Application No: AW/3/21/HH
Site Address: 4 Shorecroft Aldwick PO21 4AS
Description of works: Single storey rear extension and loft conversion with enlarged rear dormer window and two modest front facing dormer windows. Alterations to fenestration, Canopy to side elevation, Planter and replacement handrail to roof terrace.

Thank you for your internet representation made on 31st January 2021 which has been recorded as an objection with the comments as follows:

Drawing No. Date:
C.1062H - 04 22-12-20

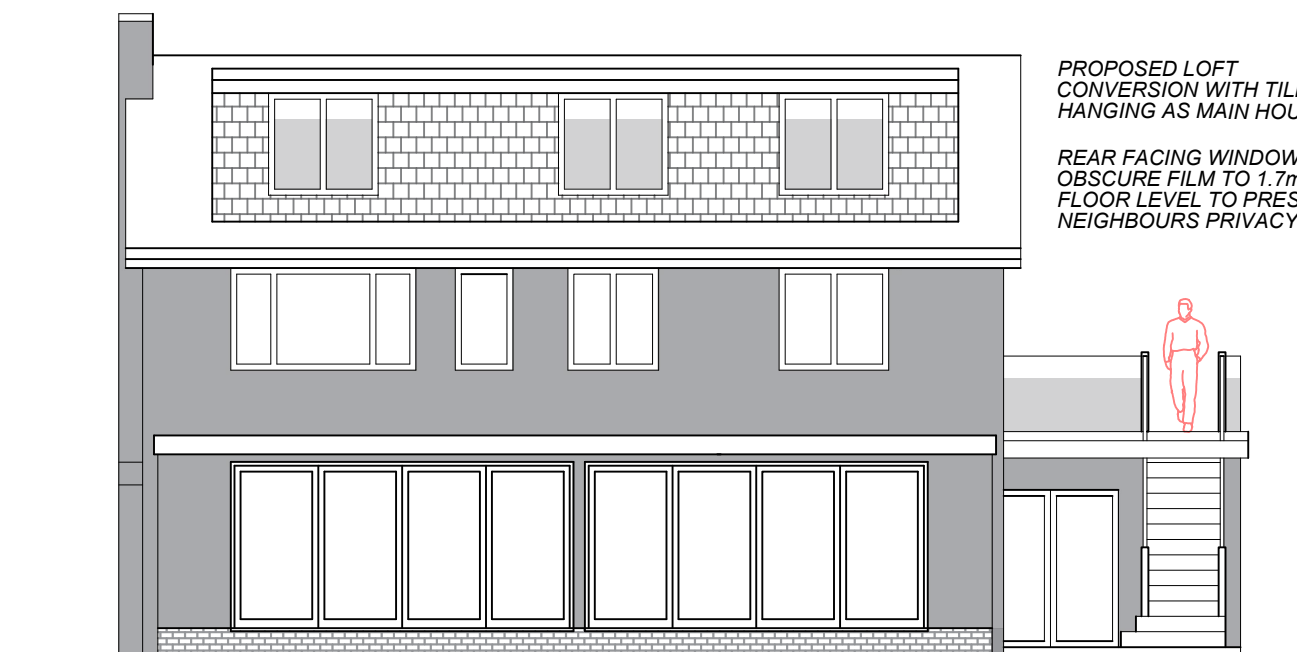
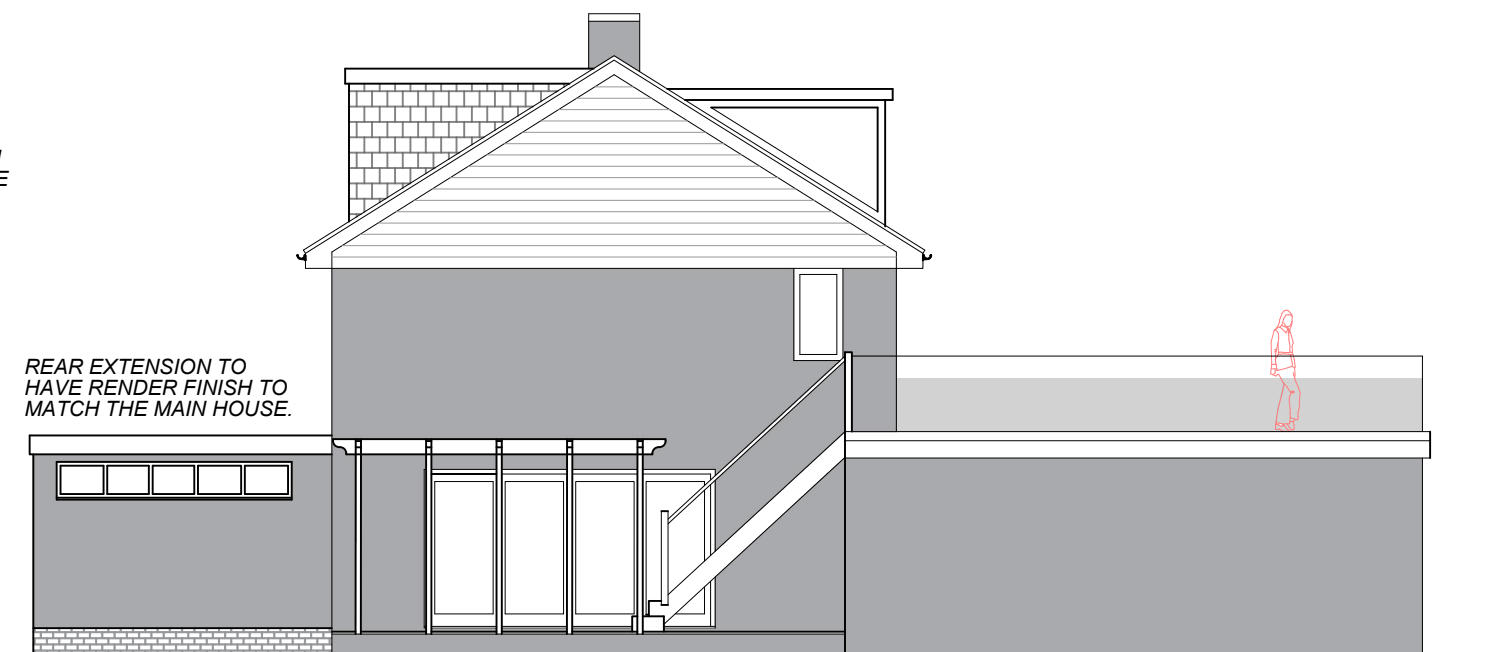
The sheer bulk of the the full width/height rear dormer will be very intrusive & the proposed obscure glass will not disguise the structure which will be visible from our garden & could at certain times of the year block the sun. It will also be visible from the gardens at 6 & 8 Shorecroft + the windows & gardens of 12,14 & 16 Aldwick Place.

The side profiles of the front & rear dormers will be seen from 2 windows in our bedroom as well as our roof terrace & will dominate & overshadow our outdoor space & could also obscure the sun.

The previous owners officially converted the rear of the garage into an office & the front portion was used for storage. It is noted that the plans for the east elevation (facing our property) show 2 new high level windows in this location. The floor plans mark the dividing wall + a window in each section but there is no indication of what the area will be used for after these windows have been installed.

PROPOSED ROOF PLAN

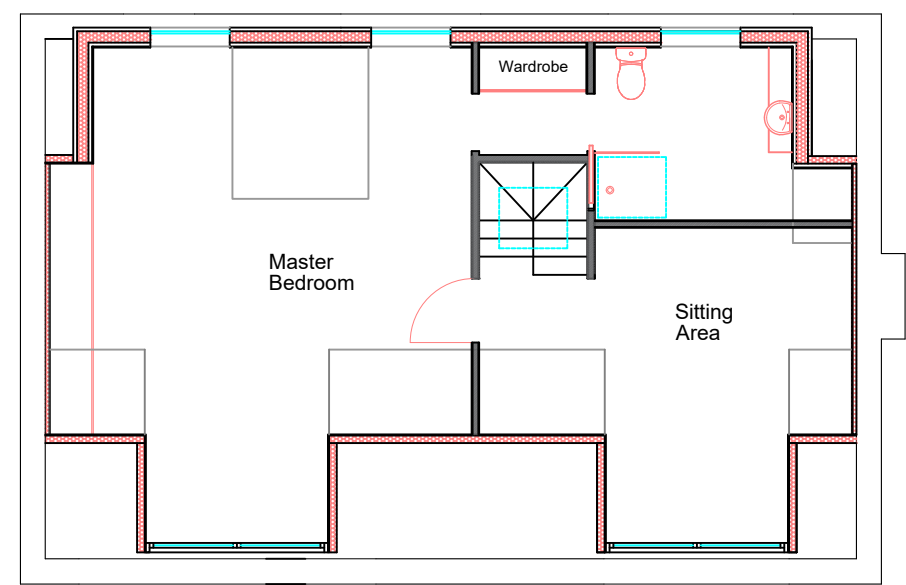
- a) refers to the front dormers as being 'modest' but without actually measuring the plans they look approx 1.8 - 2.4M wide & 2.4M high, which is not modest
- b) refers to the dormers at 7 & 9 Hornbeam which is somewhat irrelevant as they are not even visible from Shorecroft. The chalet bungalows are at the end of a cul-de-sac & the one small dormer on each property are viewed from the front elevation & does not detract from the overall street scene
- c) states that the proposed glass balustrade will be similar in appearance to those at 3 Shorecroft - which is beachside & 3 Aldwick Place - much smaller & hardly noticeable as it doesn't project beyond the front elevation of the house. More importantly, neither are visible from this location.
